## **Eastern Creek REP Throughput Increase (SSD 11606719)**

### **Department's comments on Amendment and Submissions Report**

**22 November 2023**

ROADWORKS AND STORMWATER DRAINAGE PLAN SHEET 1

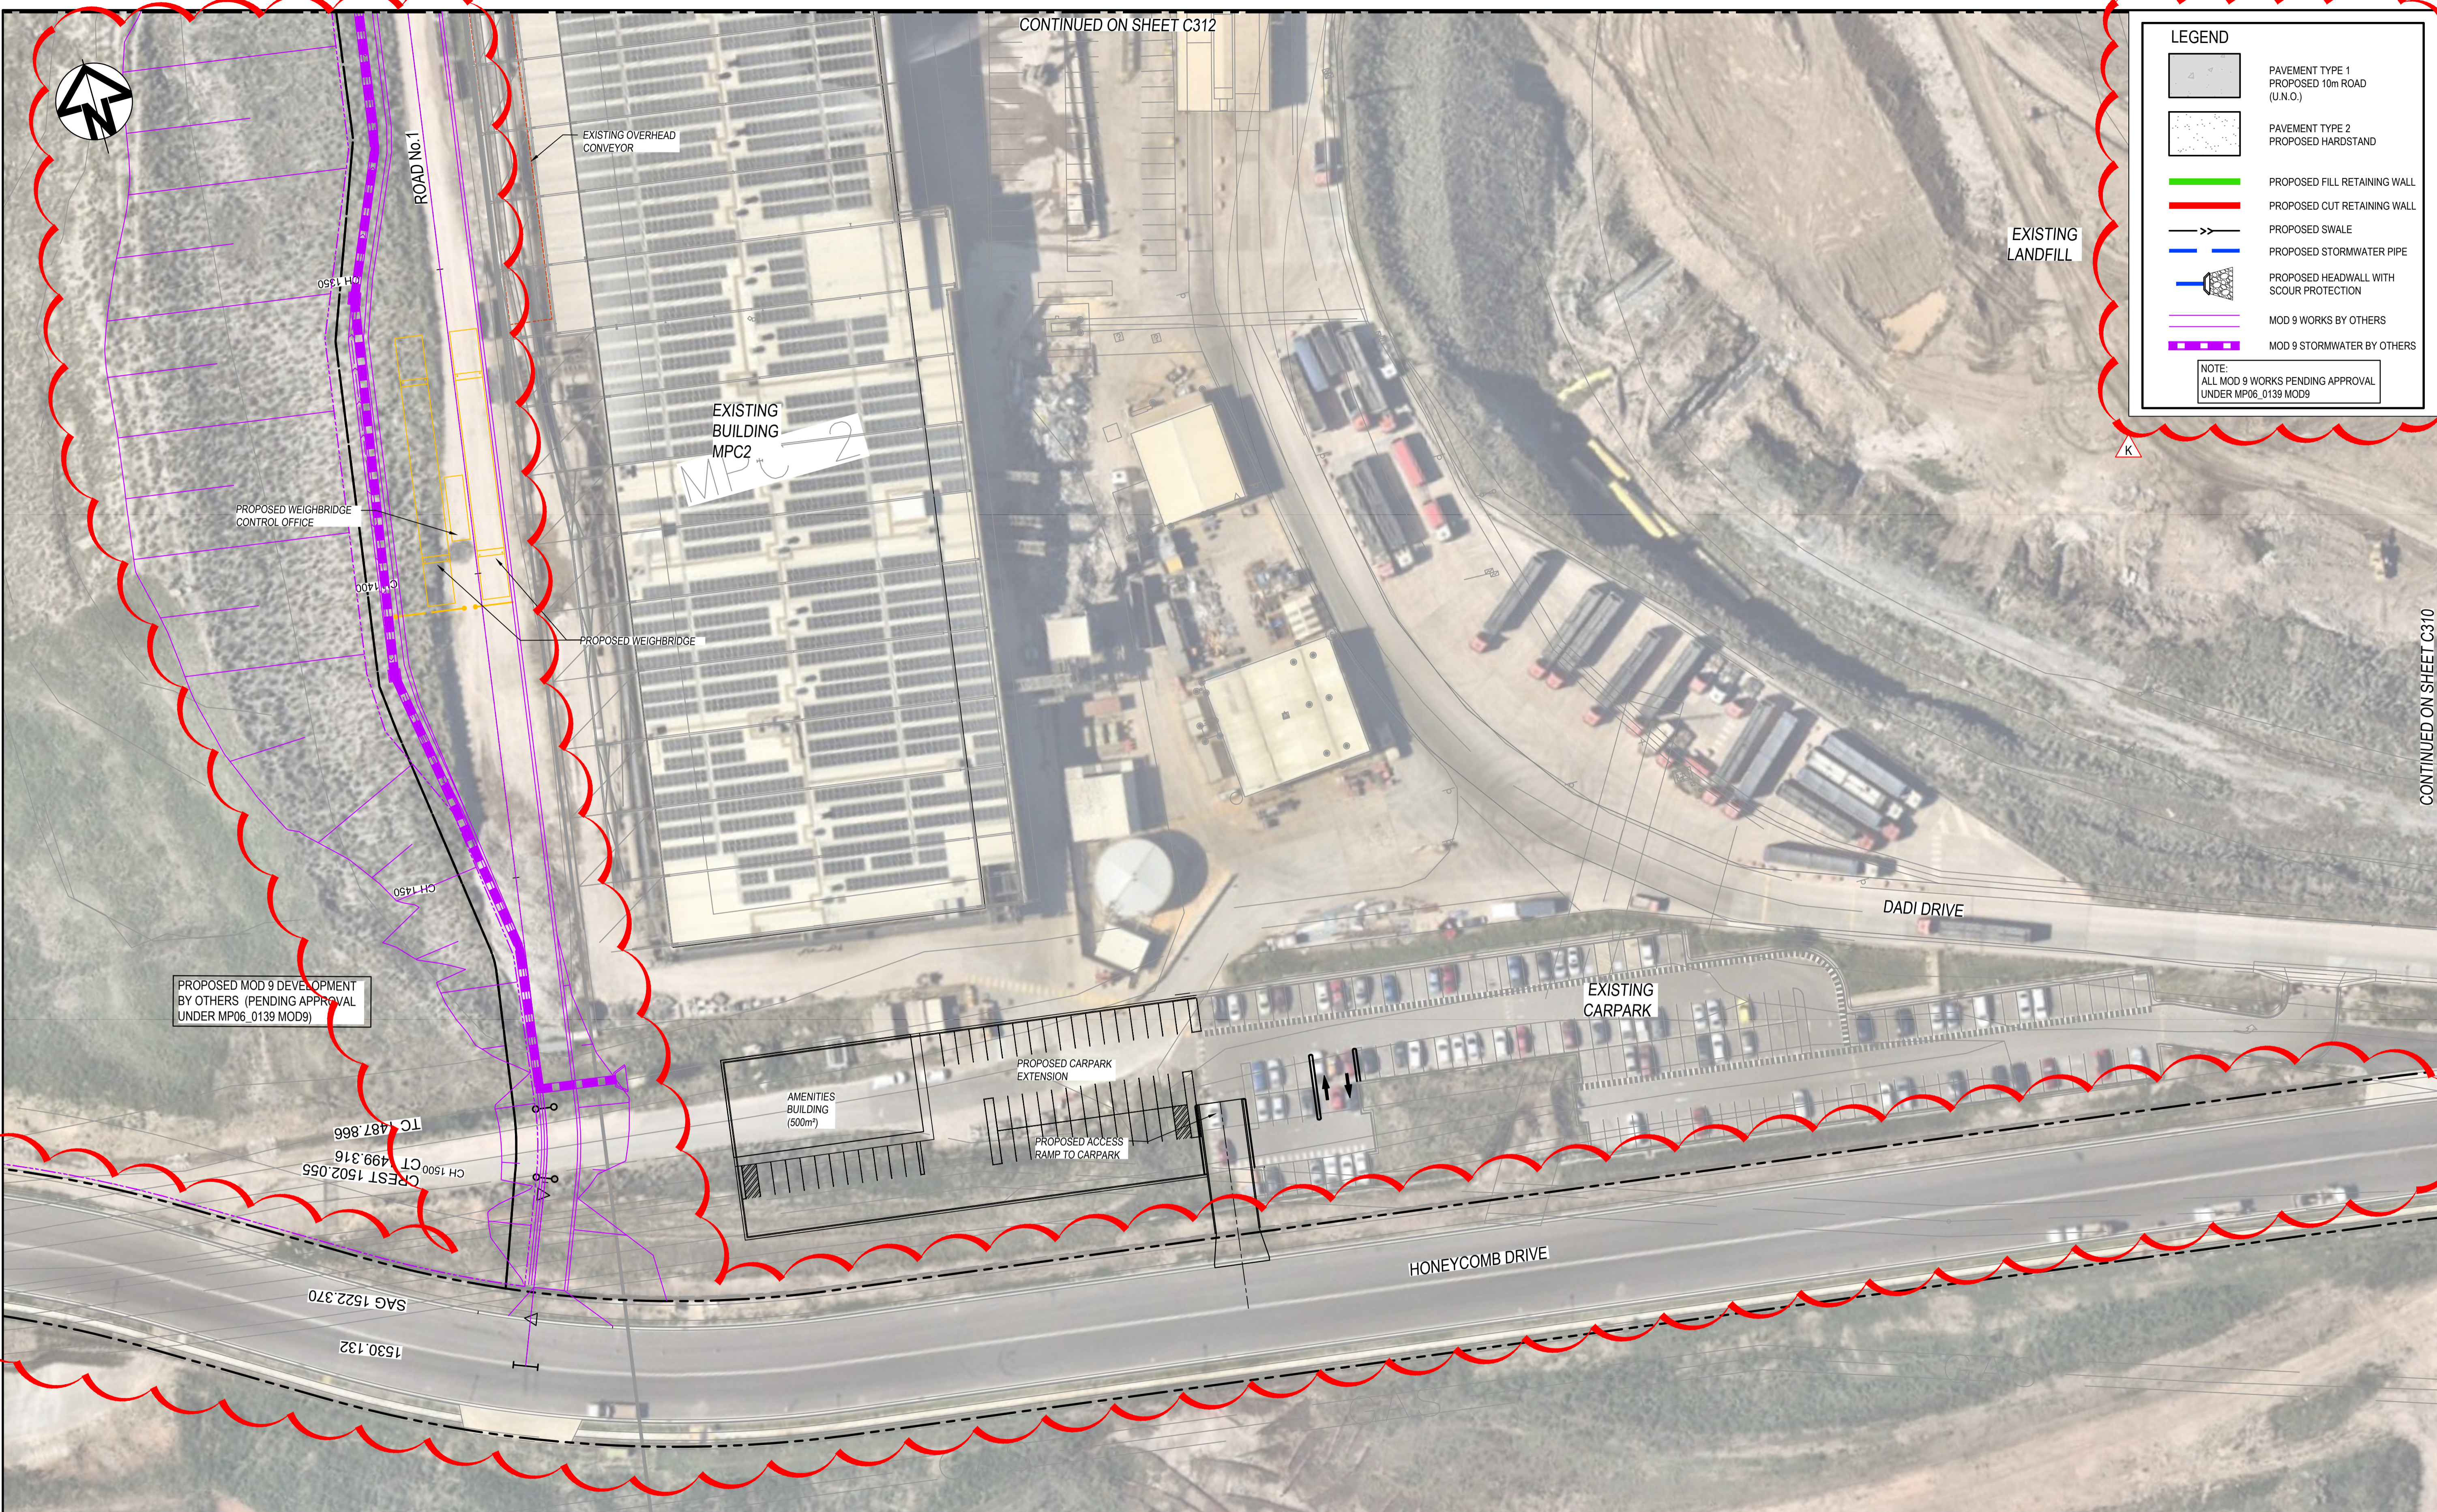
- Please clarify how many weighbridges are proposed at the new exit road to Honeycomb Drive. The ASR is inconsistent, in some places stating there would be one weighbridge while in other places it states there would be two.
- Provide further details of the upgrades to the existing internal roads, including information on the proposed road surface.
- Clarify the operating hours and days for the Site Workshop and Manufacturing and Maintenance Workshop.
